WEST SUSSEX COUNTY COUNCIL CONSULTATION

TO:	Arun District Council FAO: Maria Tomalova
FROM:	WSCC - Highways Authority
DATE:	10 March 2022
LOCATION:	Cordell House Rest Home 120 Victoria Drive Bognor Regis PO21 2EJ
SUBJECT:	BR/37/22/PL Change of use from residential care home (Use C2) to a 10 bed House in Multiple Occupation (Sui Generis). This application is in CIL Zone 4 and is Zero Rated as other development.
DATE OF SITE VISIT:	n/a
RECOMMENDATION:	No Objection
S106 CONTRIBUTION TOTAL:	n/a

PROPOSED GROUND FLOOR PLAN

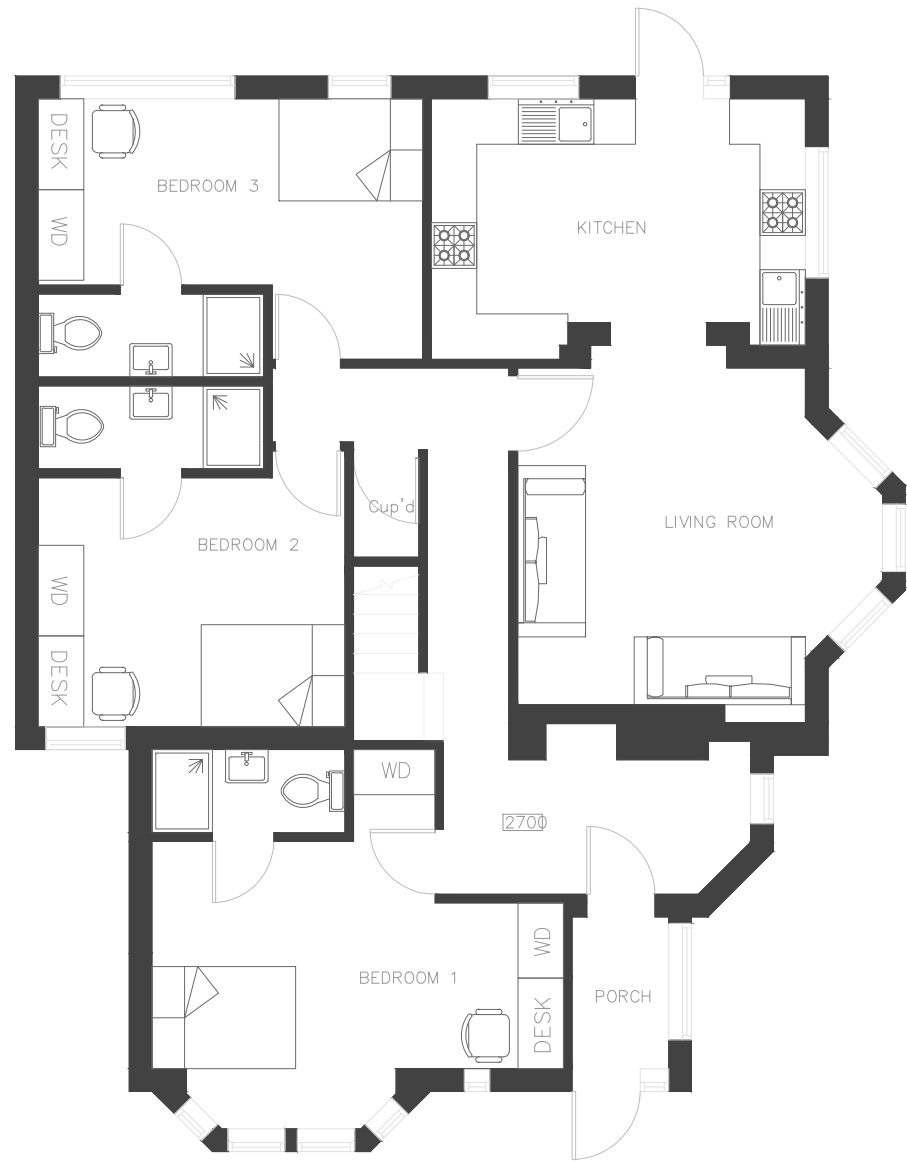
Safe and secured cycle storage facility is provided for 10 nos. bicycles, one space for each room, to the rear of the property. A bin store for storing refuse and recycling bins is provided at the front of the building for easy access and to be collected from kerbside on the day of collection.

No part of the development shall be first occupied until covered and secure cycle parking spaces have been provided in accordance with plans and details submitted to and approved by the LPA.

Drawing
Site Plan

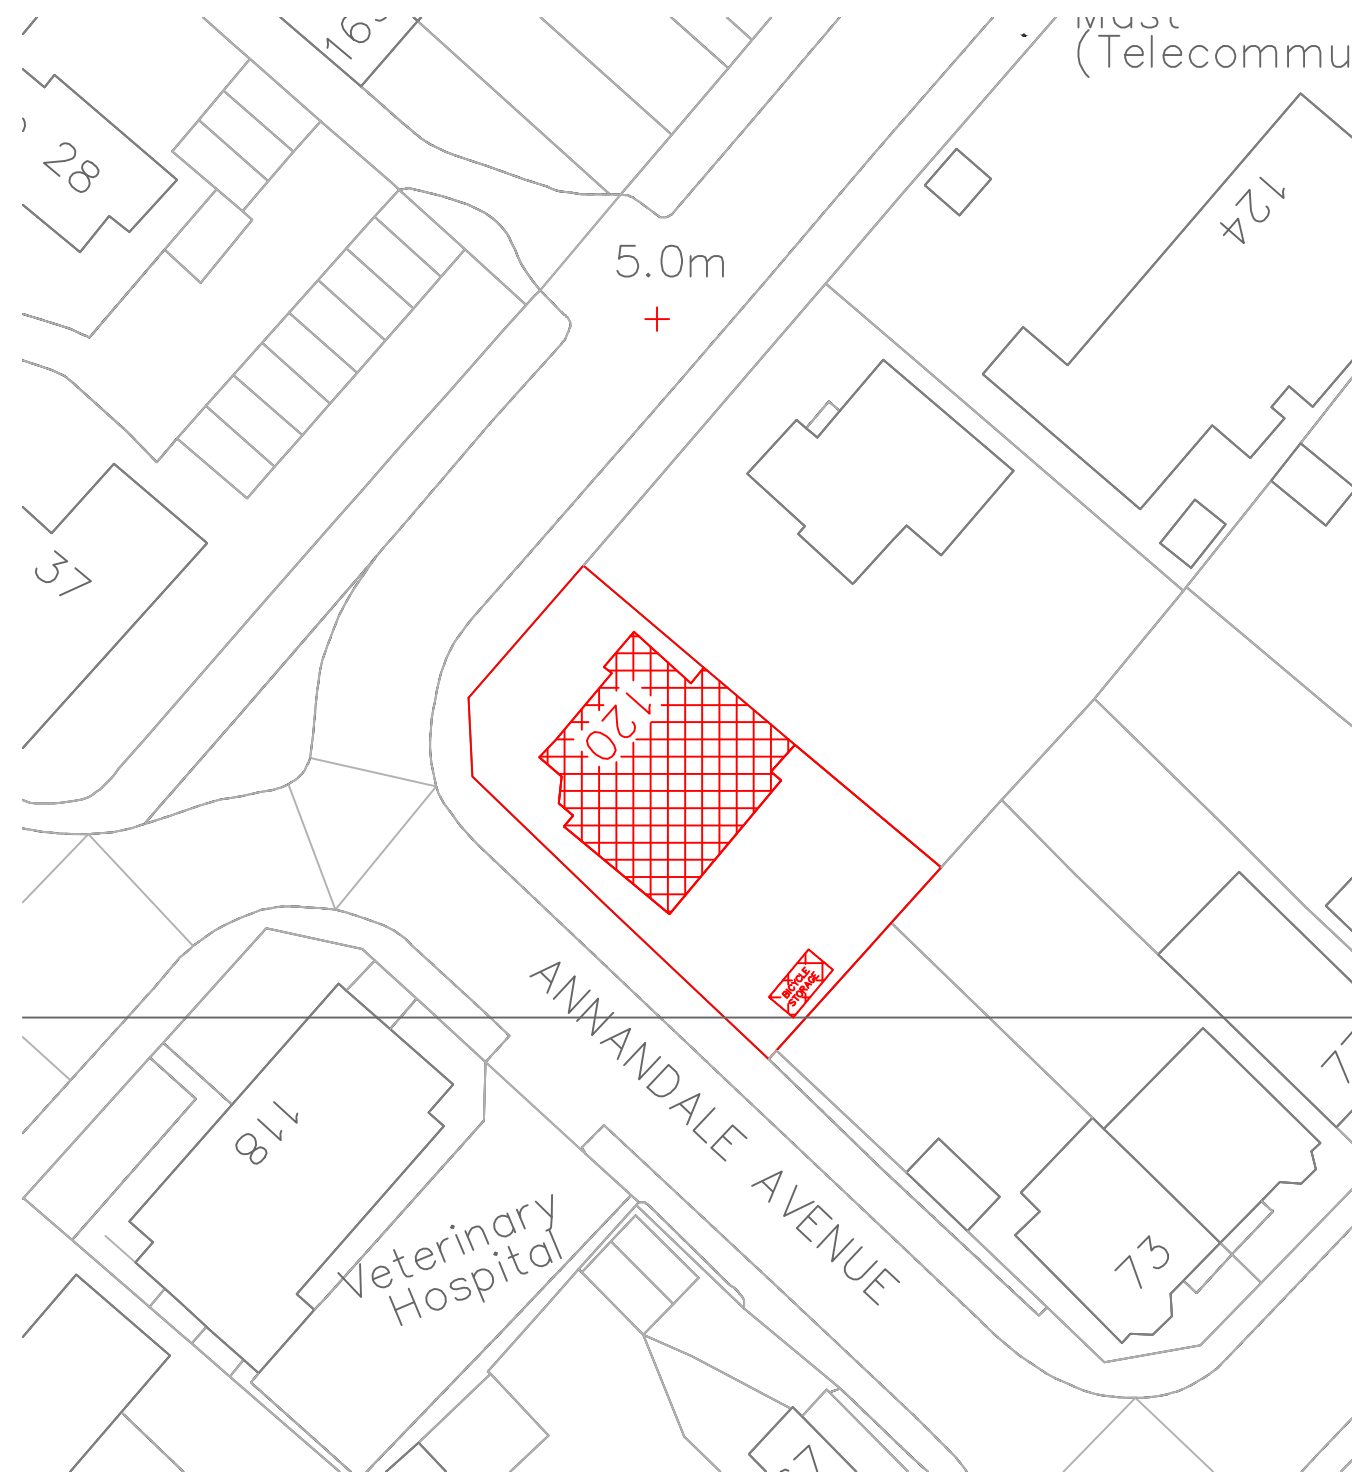
The proposed development will provide 2nos. car parking spaces. A car parking survey conducted on the neighbouring residential streets reveals that out of the total 299 parking spaces, only 200 were occupied which gives a 66% occupancy rate. Therefore, it is considered that there are ample spaces within surrounding streets should the residents wish to park. In terms of any on-street parking there

No part of the development shall be first occupied until the vehicle parking spaces have been constructed in accordance with the approved plan. These spaces shall thereafter be retained for their designated use.
